Consultation Response from: KC Environmental Health (Pollution & Noise Control)
2025/92737 - rear of, 23 to 43, Moor Lane, Gomersal, Cleckheaton, BD19 4LF

Discharge of details reserved by conditions 10 (Phase II Intrusive Site Investigation Report), 11 (Remediation Strategy), 14(a) (coal mining activity), 16, 17, 18, 19, 20 (drainage), 21 (CEMP), 23 (estate roads), 24 (acoustic barrier) on previous permission 2023/92079 for outline application for erection of residential development of 10 dwellings, demolition of existing extension at 27 Moor Lane, widening of existing access and realignment of boundary walls.

Date Responded:
Wednesday, 27 May 2026
Responding Officer:
HK
Responding Ref:
WK/202533227

Access Road Eastern Elevation (towards 25 Moor Lane) as proposed 1: 100

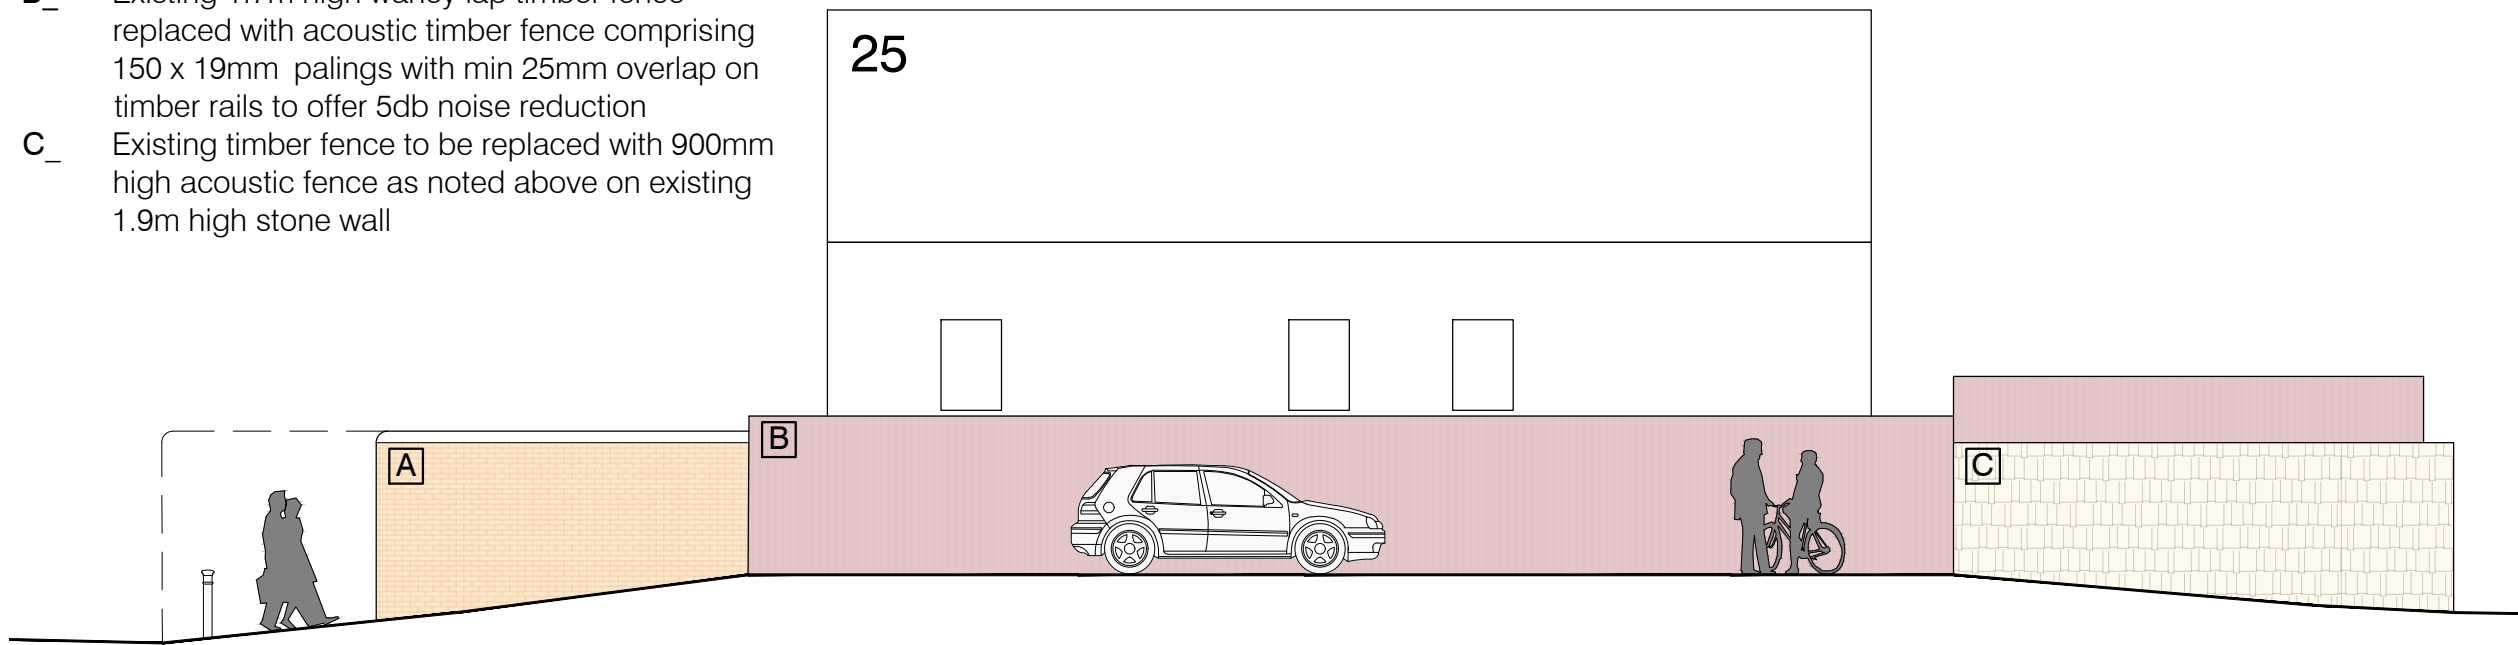
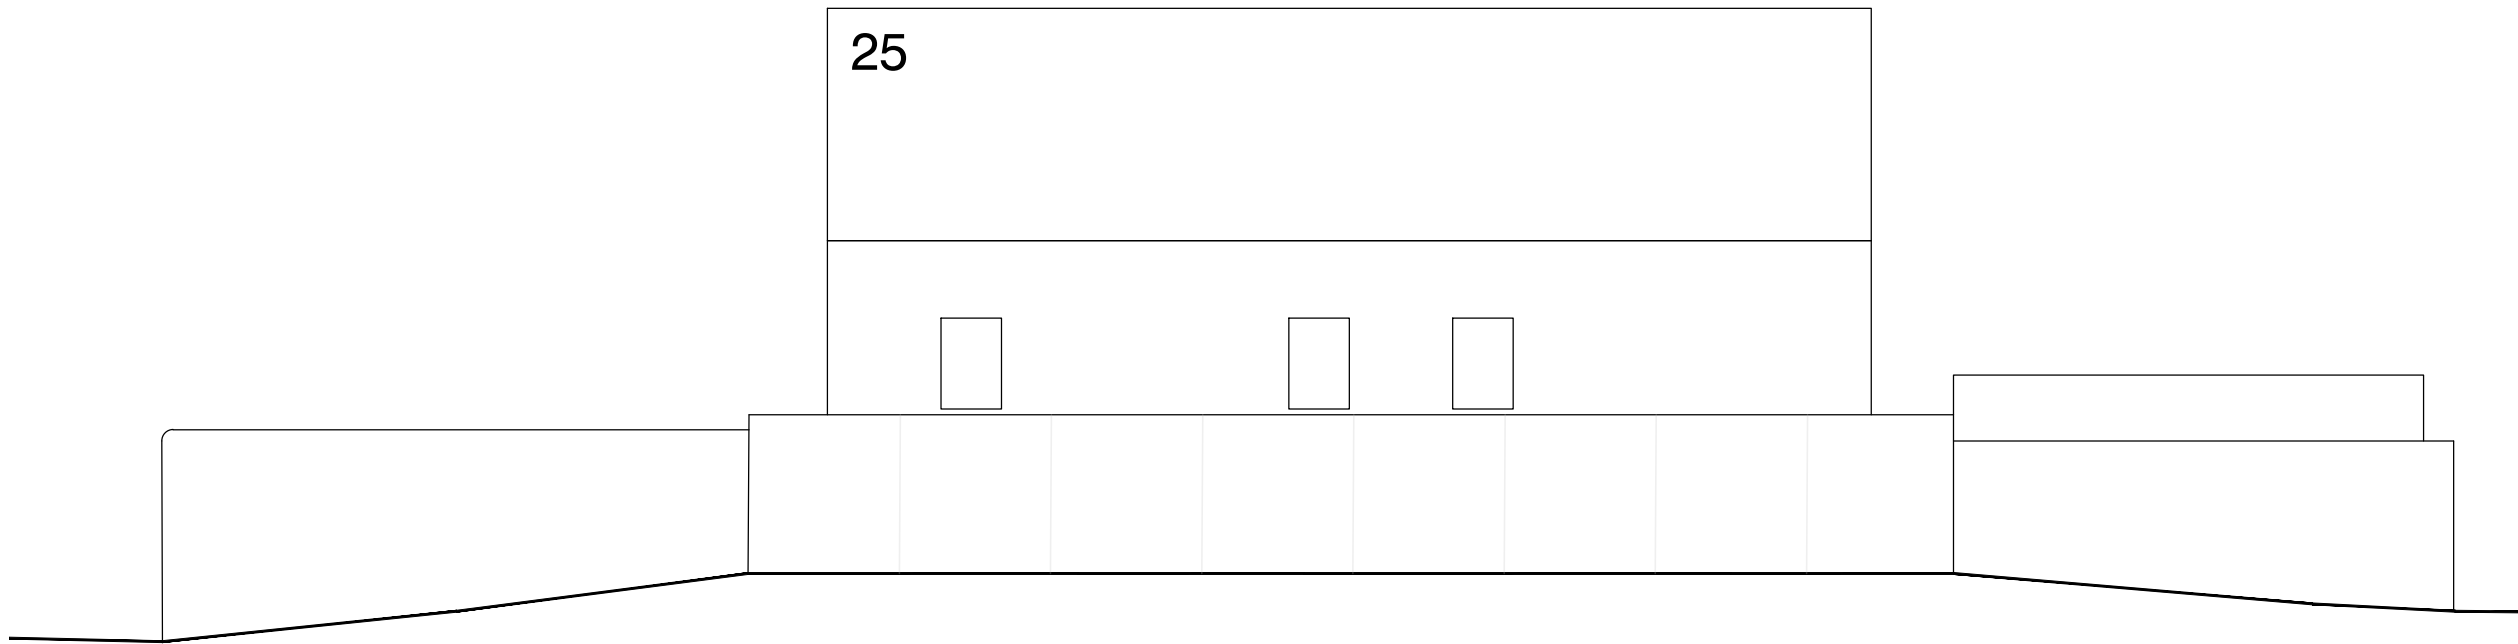
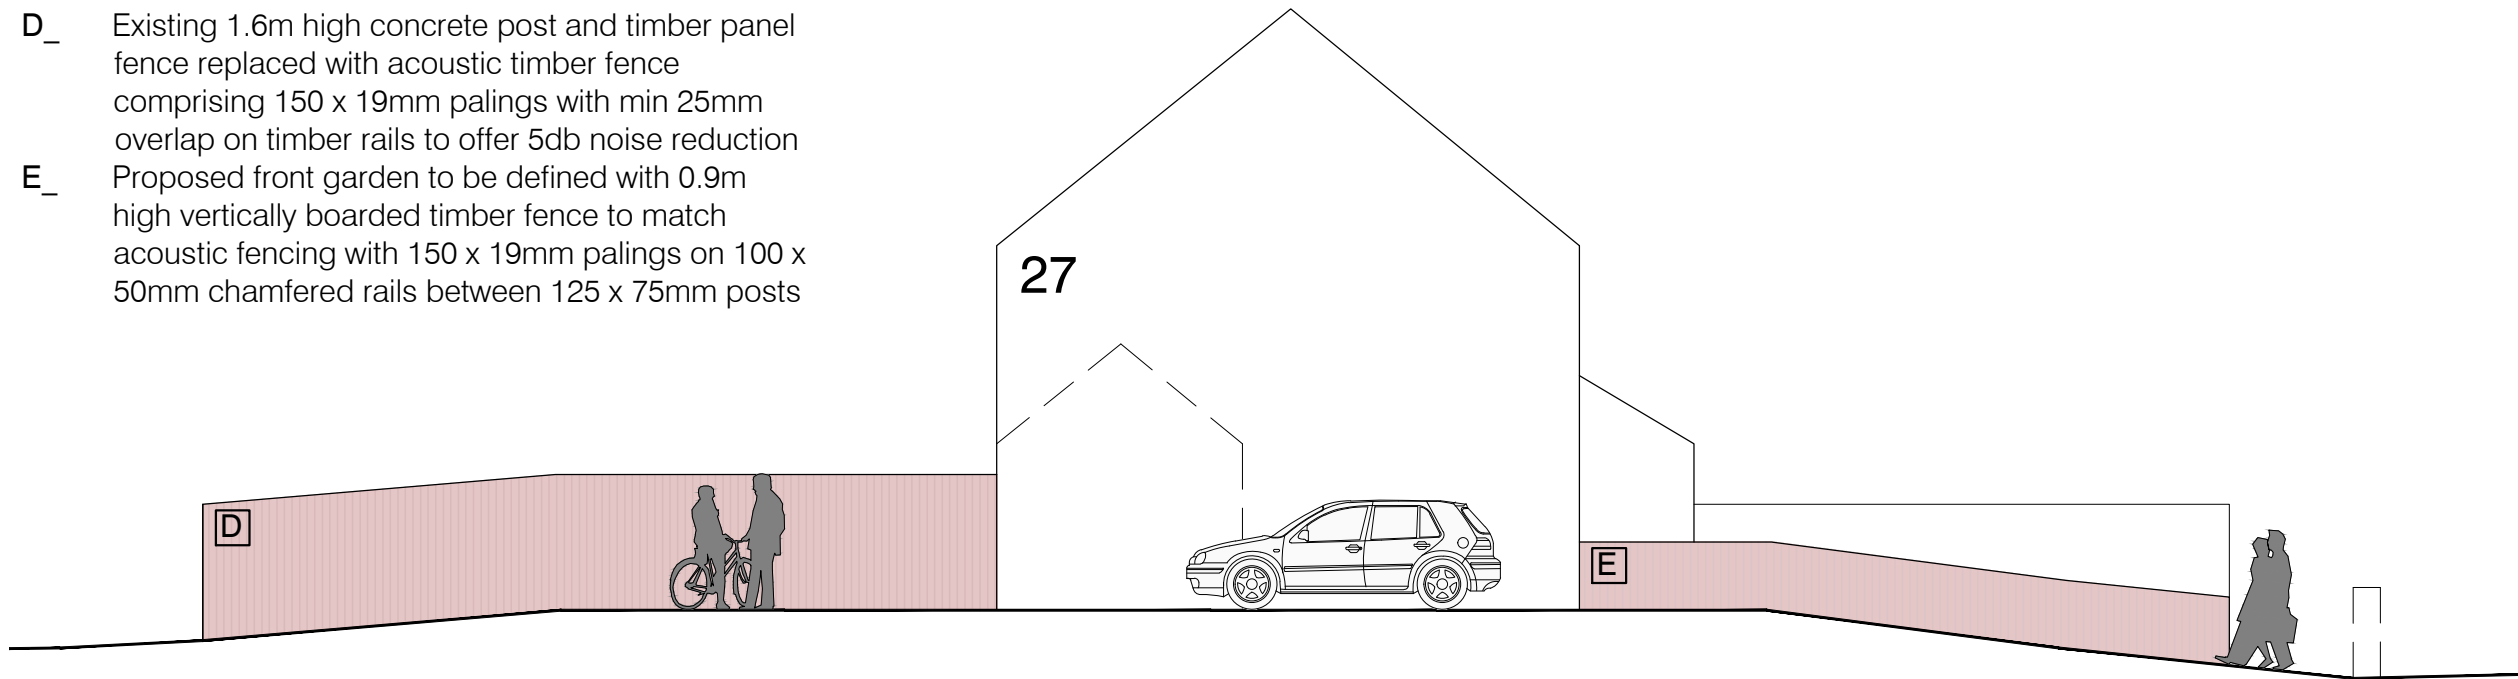
Condition 24: The submitted application form refers to: “*Condition 24: 21942-10 Access Road Elevations*” submitted for the discharge of condition 24. Environmental Health are not aware of the background / basis for condition 24, but it would appear that the purpose of an acoustic barrier in the location proposed would be to mitigate noise from road traffic accessing the site. Based on the information presented in the submitted drawing Ref: 21942-10 Access Road Elevations, dated July 2023, the proposed acoustic barrier could only achieve noise reductions at ground floor level. Noise from road traffic accessing the site will not be reduced by the installation of a noise barrier at first floor (bedroom window height). Noise reductions at first floor level could only be achieved by installing acoustic glazing – as can be seen in the drawing Ref: 21942-10 Access Road Elevations, dated July 2023:

- A_ Existing brickwork wall with stone coping reduced in length to respect visibility splay
- B_ Existing 1.7m high waney lap timber fence replaced with acoustic timber fence comprising 150 x 19mm palings with min 25mm overlap on timber rails to offer 5db noise reduction
- C_ Existing timber fence to be replaced with 900mm high acoustic fence as noted above on existing 1.9m high stone wall

Access Road Eastern Elevation (towards 25 Moor Lane) as proposed 1: 100

A direct line of site  from first floor windows will not be mitigated by the acoustic barrier at the neighbouring dwellings. Furthermore, without a report prepared by a competent acoustic consultant, it cannot be confirmed that the proposed noise barrier will achieve the 5dB noise reductions.

Without further background, Environmental Health cannot comment further on condition 24.
